KIRKLEES METROPOLITAN COUNCIL INVESTMENT & REGENERATION SERVICE

Reference No:	2023/62/92532/W
Site Address:	11, Town End Avenue, Wooldale, Holmfirth, HD9 1QW
Description:	Demolition of existing garage and erection of two storey extension and construction of single storey extension including external alterations including application of render to external walls
Recommending Officer:	Lucy Taylor

Officer Report.

**Proposed Site Layout 1:200**

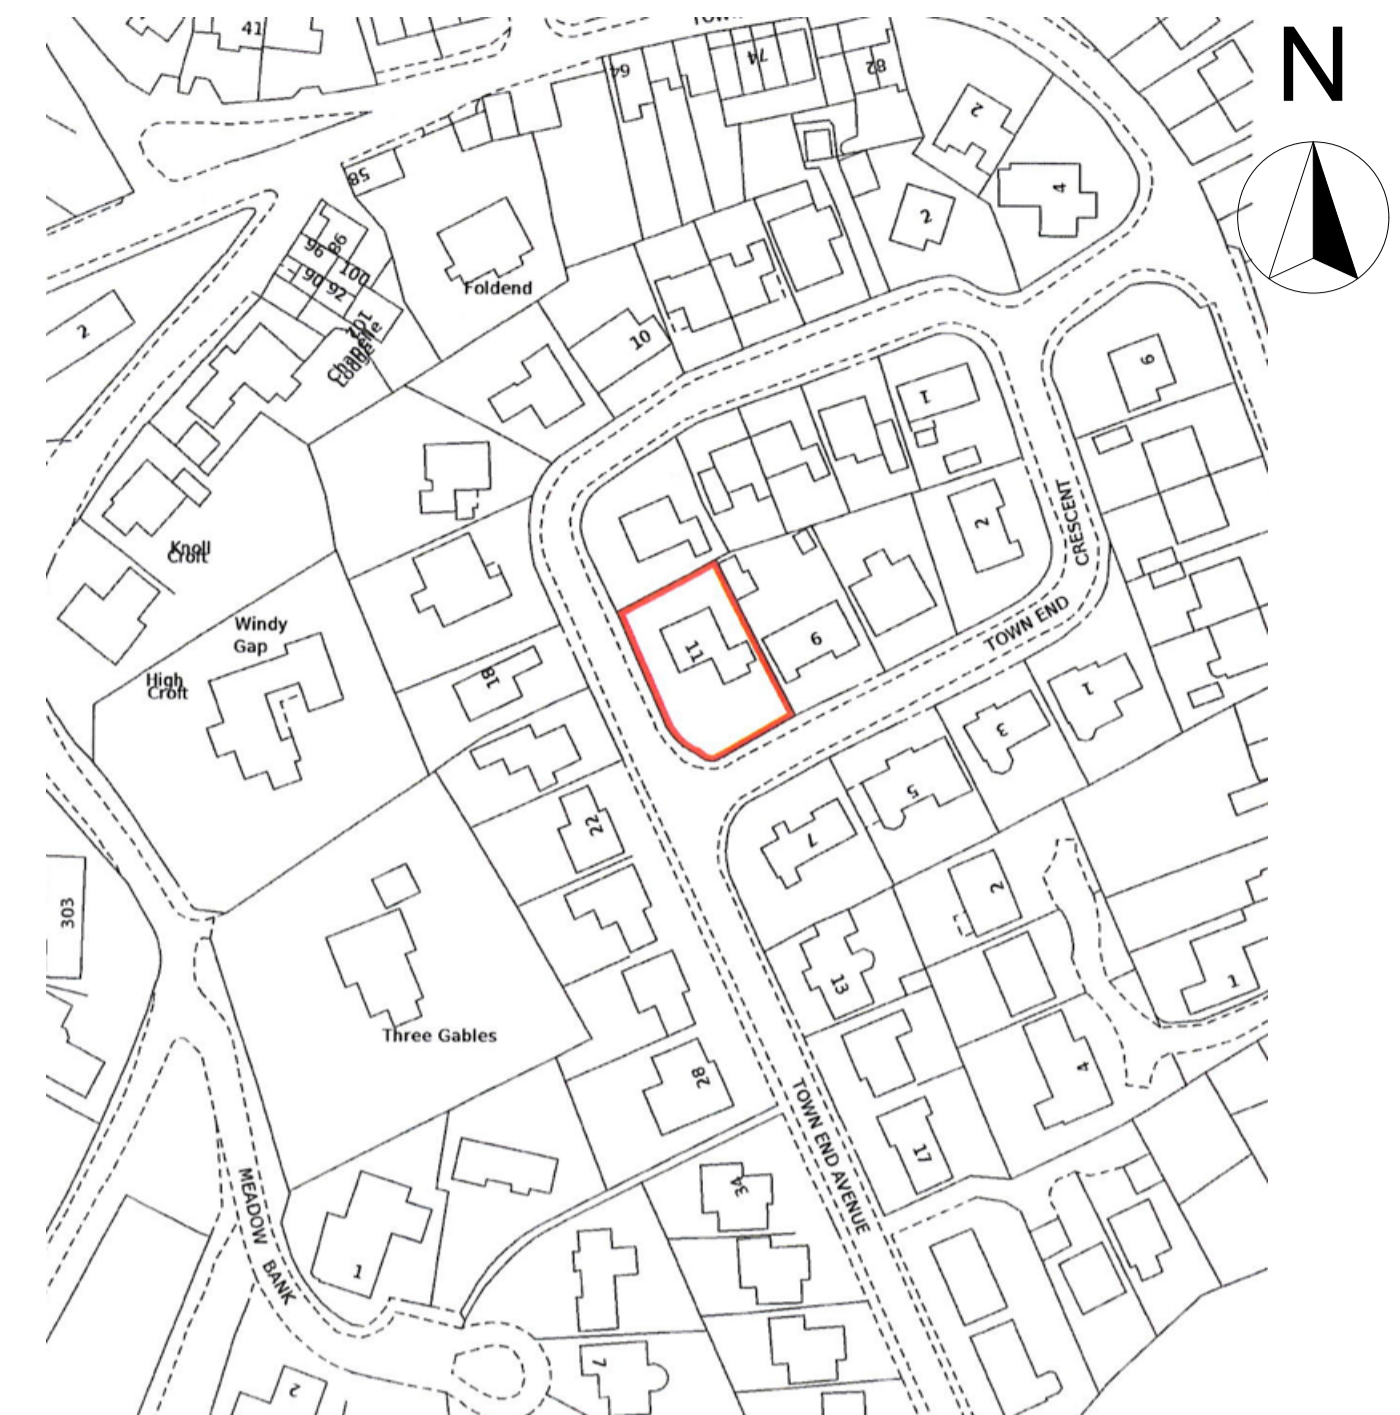
Whilst the potential number of bedrooms within the interior of the property would increase from three to four as a result of the proposed extensions, it is considered that sufficient provisions for parking are available on-site. A garage extension forms part of the works, and a driveway is to be installed to the front elevation.

Upon any grant of approval, a condition will be imposed to ensure that this driveway be surfaced in a permeable material, to ensure surface water is suitably controlled.

5. The extensions hereby approved shall not be brought into use until the driveway as indicated on the hereby approved site layout plan (dwg no. C401-001 Rev. P2) has been laid out with a hardened and drained surface in accordance with the Communities and Local Government; and Environment Agency's 'Guidance on the permeable surfacing of front gardens (parking areas)' published 13th May 2009 (ISBN 9781409804864) as amended or any successor guidance; Notwithstanding the provisions of the Town and Country Planning (General Permitted Development) (England) Order 2015 as amended (or any Order revoking or re-enacting that Order) this shall be so retained, free of obstructions and available for parking.

Layout ID: **C401-001** Revision: **P2**

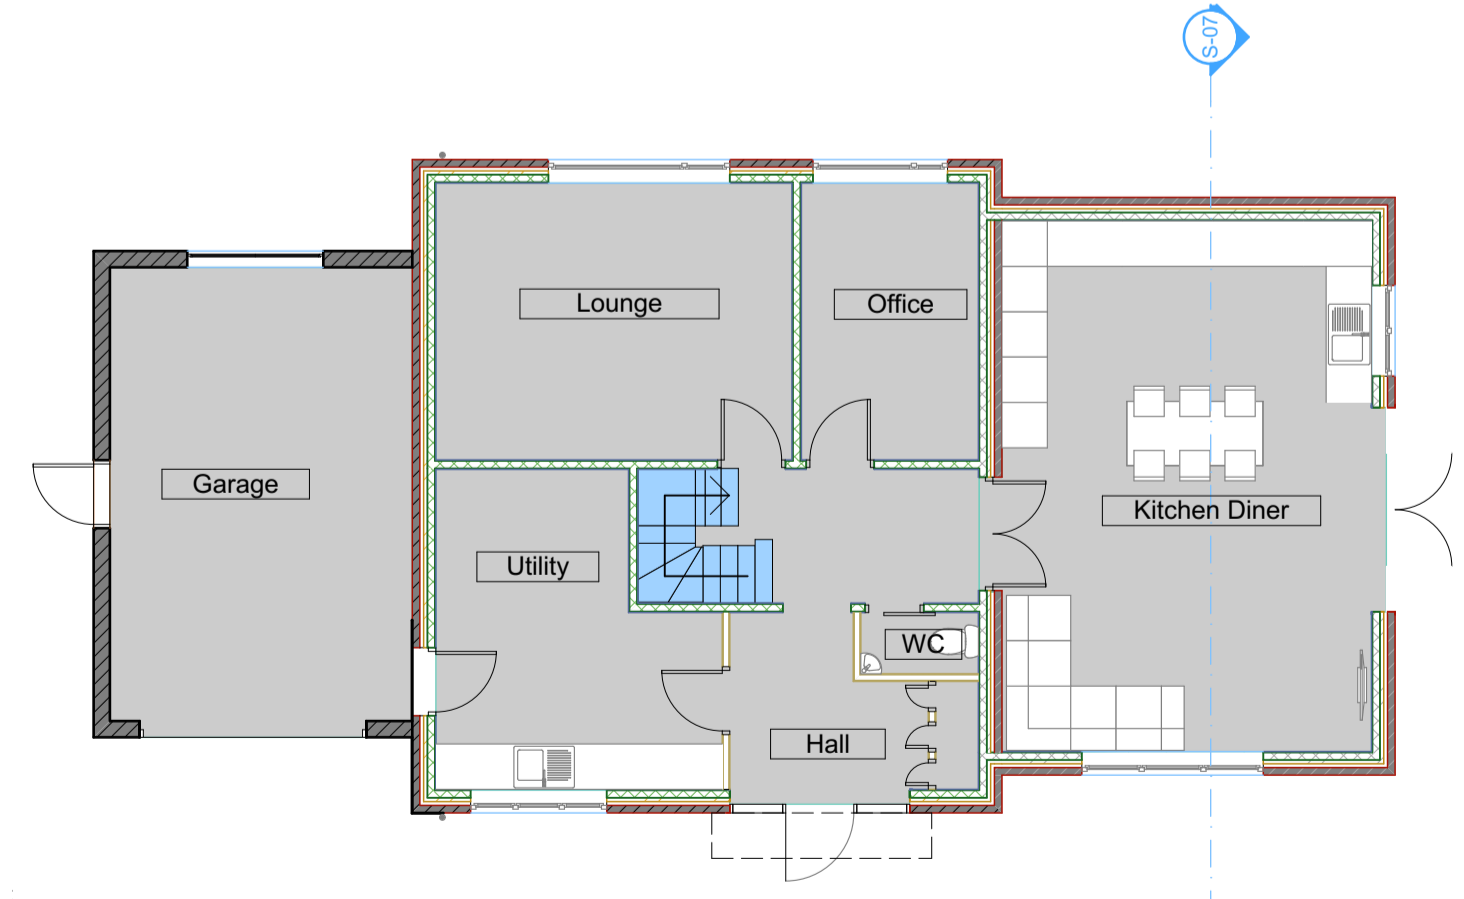
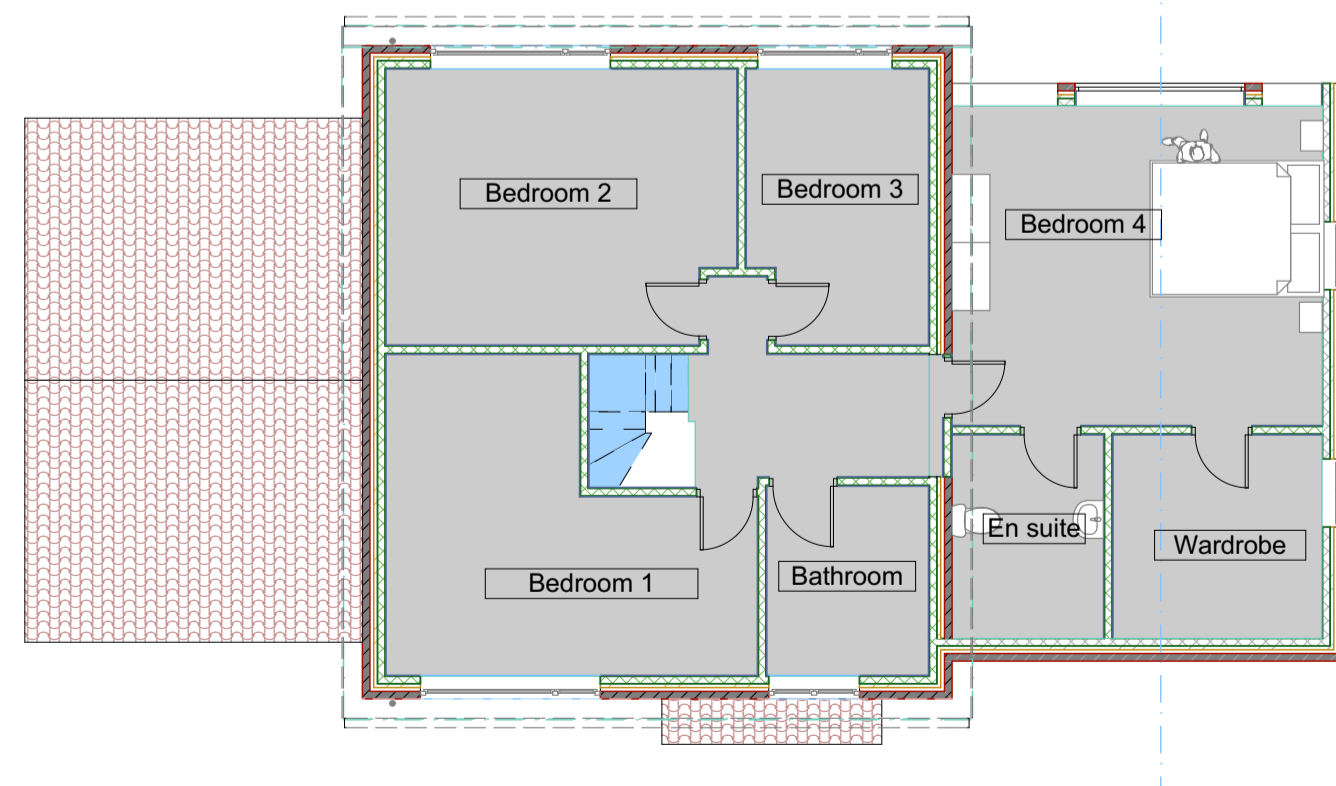
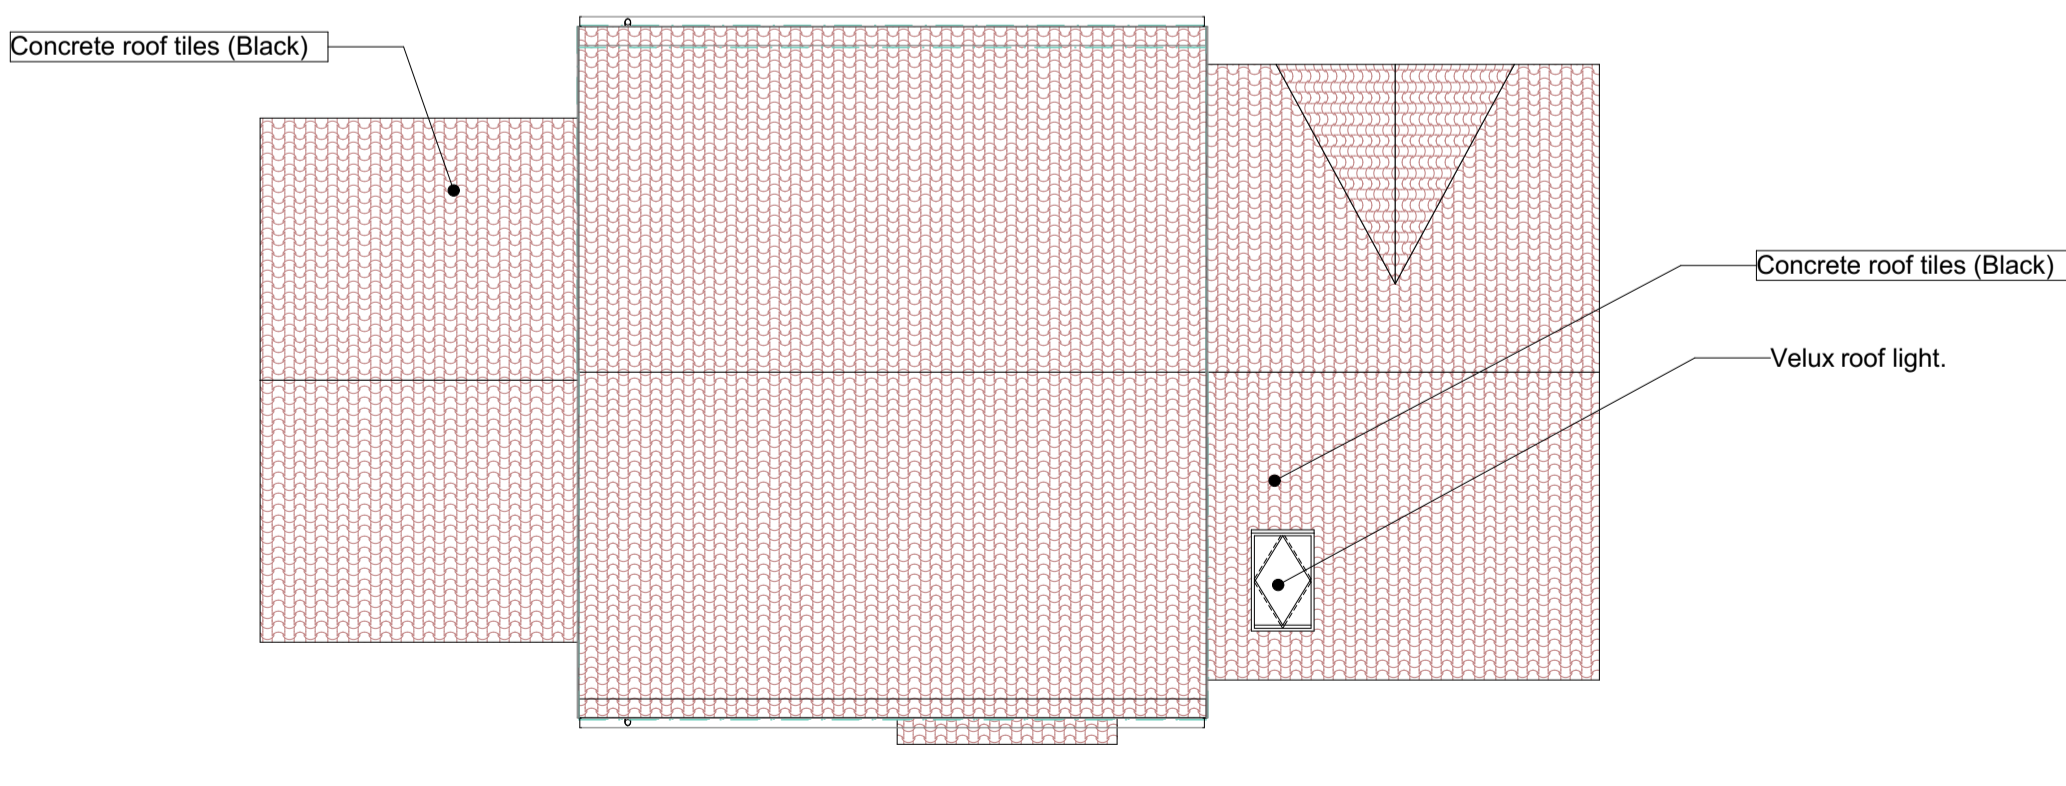
In accordance with the design principles of the House Extensions and Alterations SPD and for reasons of obtaining high standards of visual amenity and residential amenity, the case officer sought amendments to the originally proposed scheme. The extensions sought were as follows:

- Reduce the width of the proposed two-storey side extension so that it does not project beyond 2/3 of the width of the original house.
- Set the two-storey extension back 0.5 metres from the principal elevation of the original house.
- Reduce height of single storey side extension (garage) to 4 metres.
- Extent of render to principal elevation of original house remain as existing, to first floor only. Give consideration to reducing the extent of render to the proposed two-storey side extension.
- Give consideration to moving the 1st floor rear window to the side elevation of the two-storey extension.

In response to case officer recommendations, the applicant submitted amended plans. Therefore, the overall determination of this application is based on the revised drawings submitted 5th January 2024.
